SUBJECT: Engineering Review Comment
Mountain View Electric Association Inc. (MVEA)

Project Name: Honor Charter School Bent Grass Meadows PUD

Project Number: PPR2615

Description: Proposed development of a school located west of Meridian Rd and north of Bent Grass Meadows Dr in Township 13S, Range 65W, Section 1.

SITE DEVELOPMENT PLAN FOR HONOR CHARTER SCHOOL

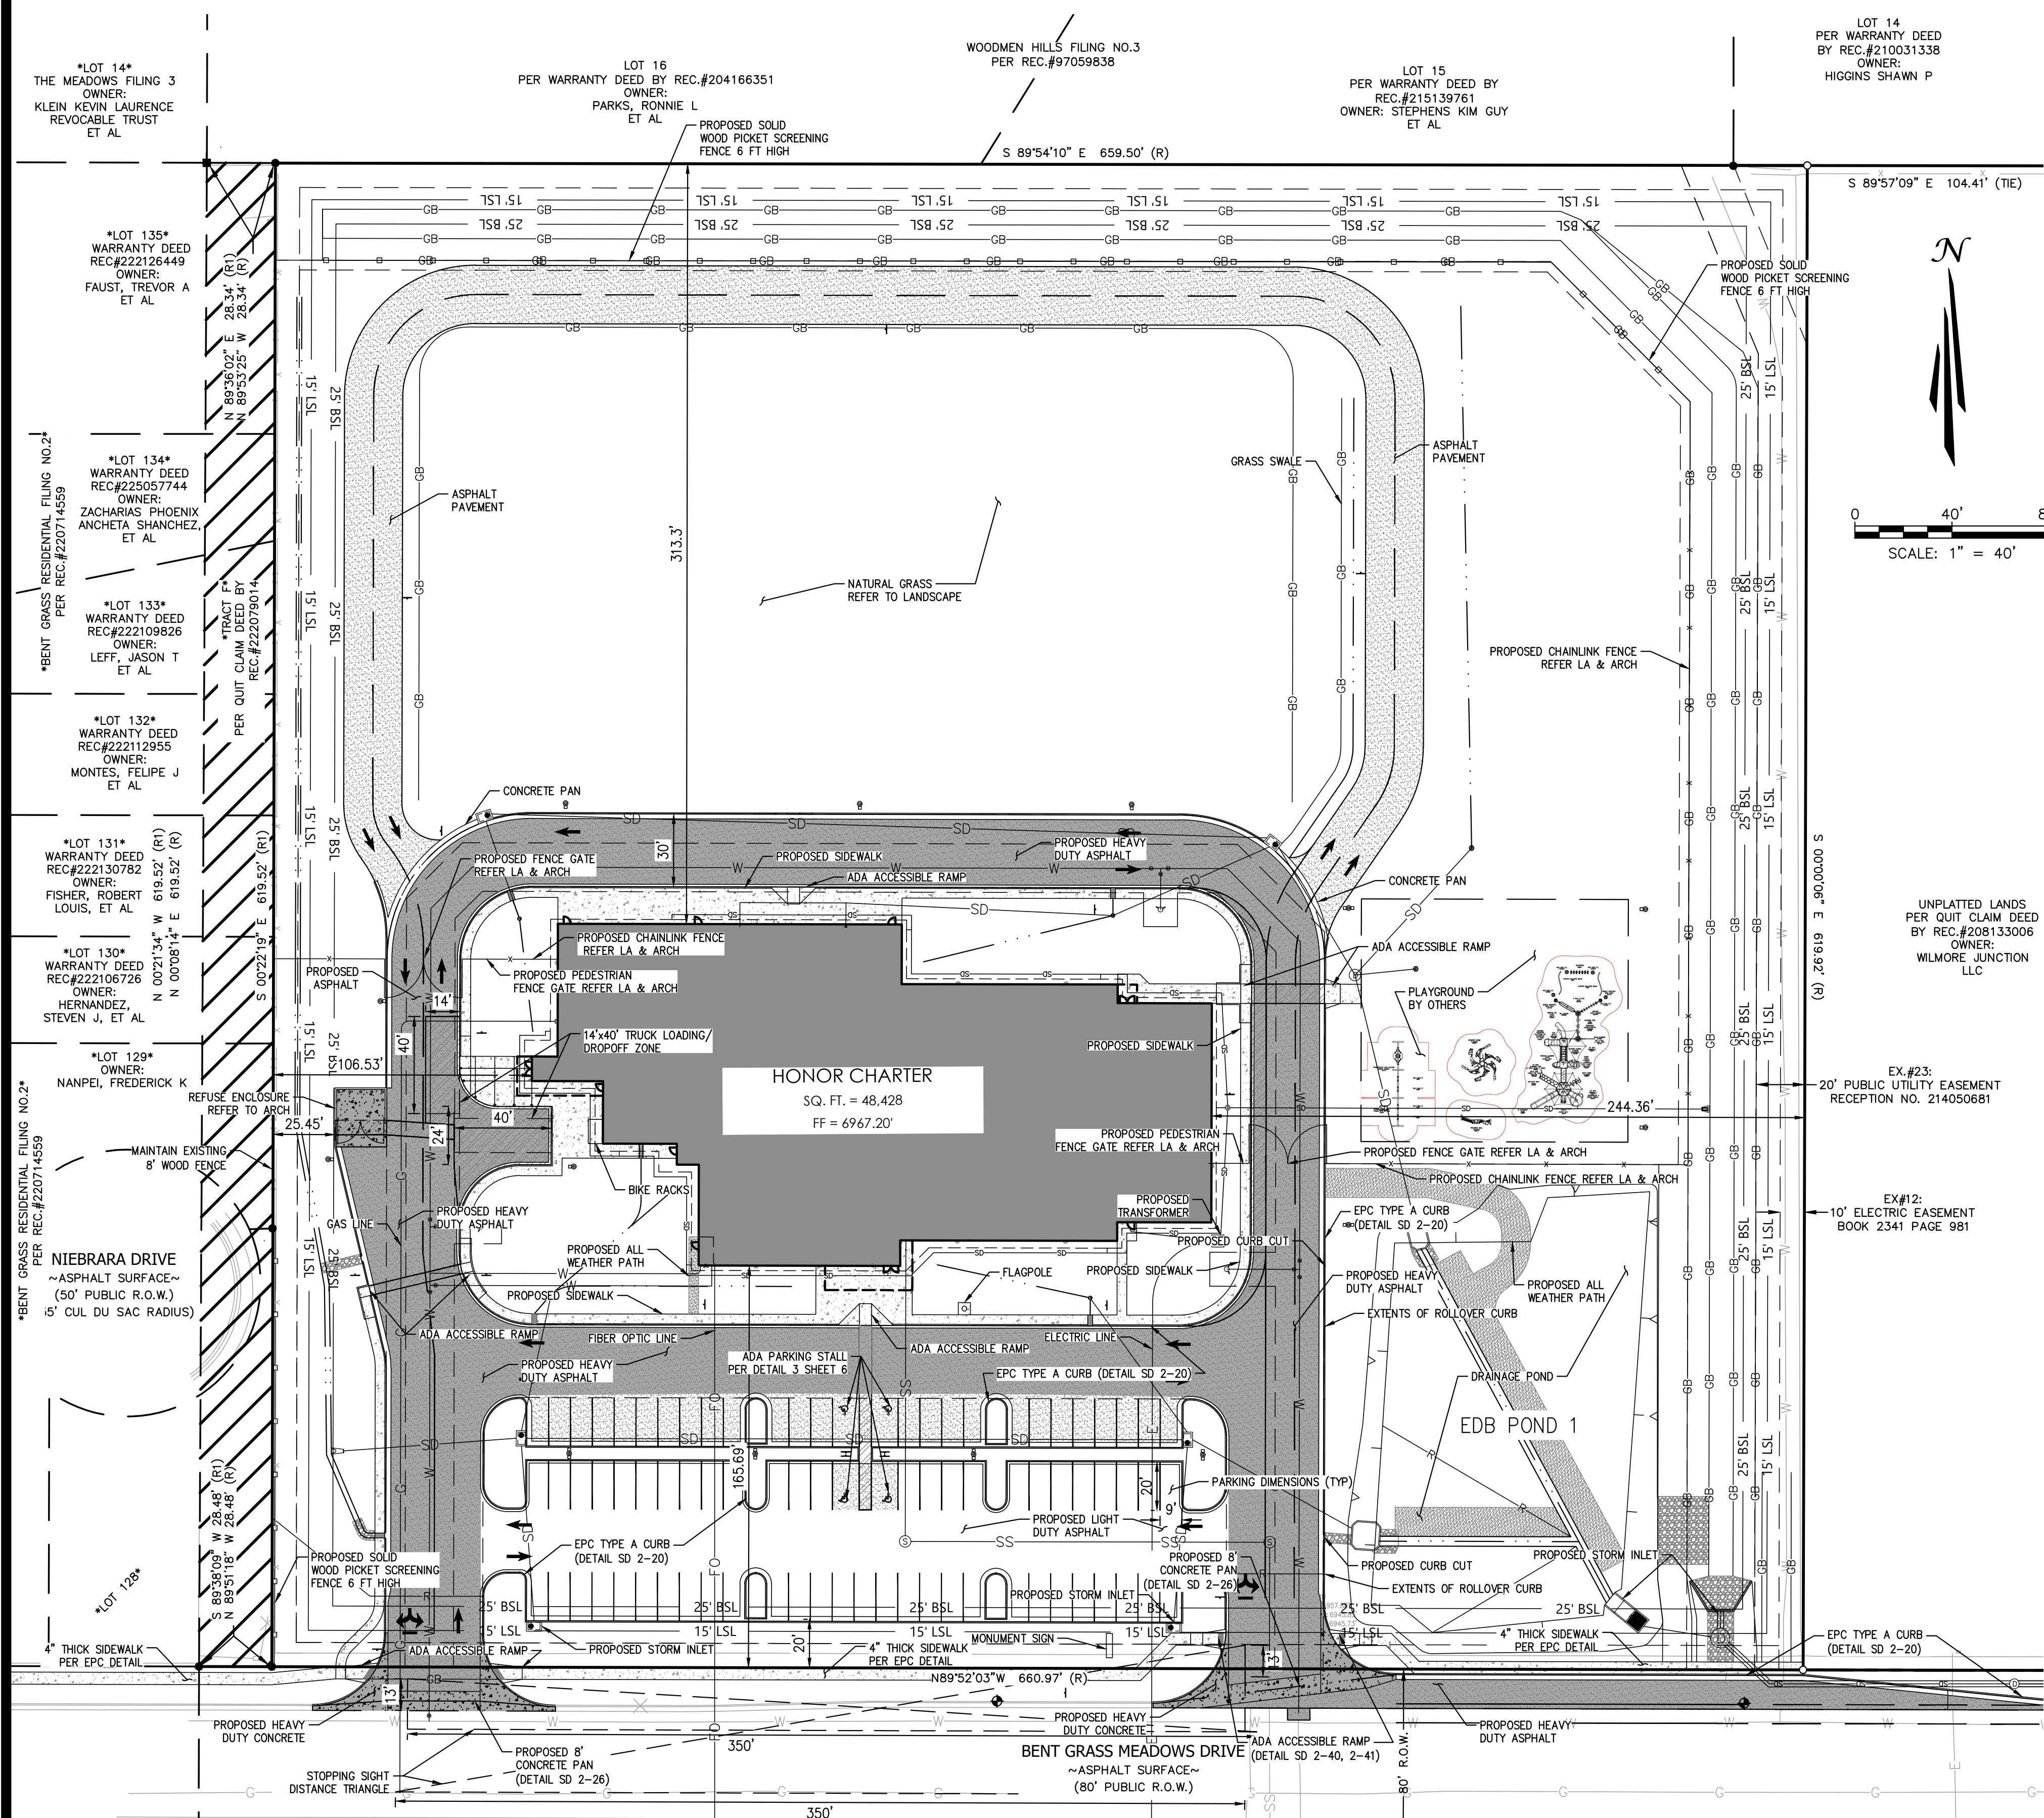
MVEA requests a ten (10) foot front, side, and rear lot utility easements on the plat and will work with the developer on the design of the electric service. MVEA also requests the platting of MVEA's existing facilities with easements on the plat. Additional easements may be required.
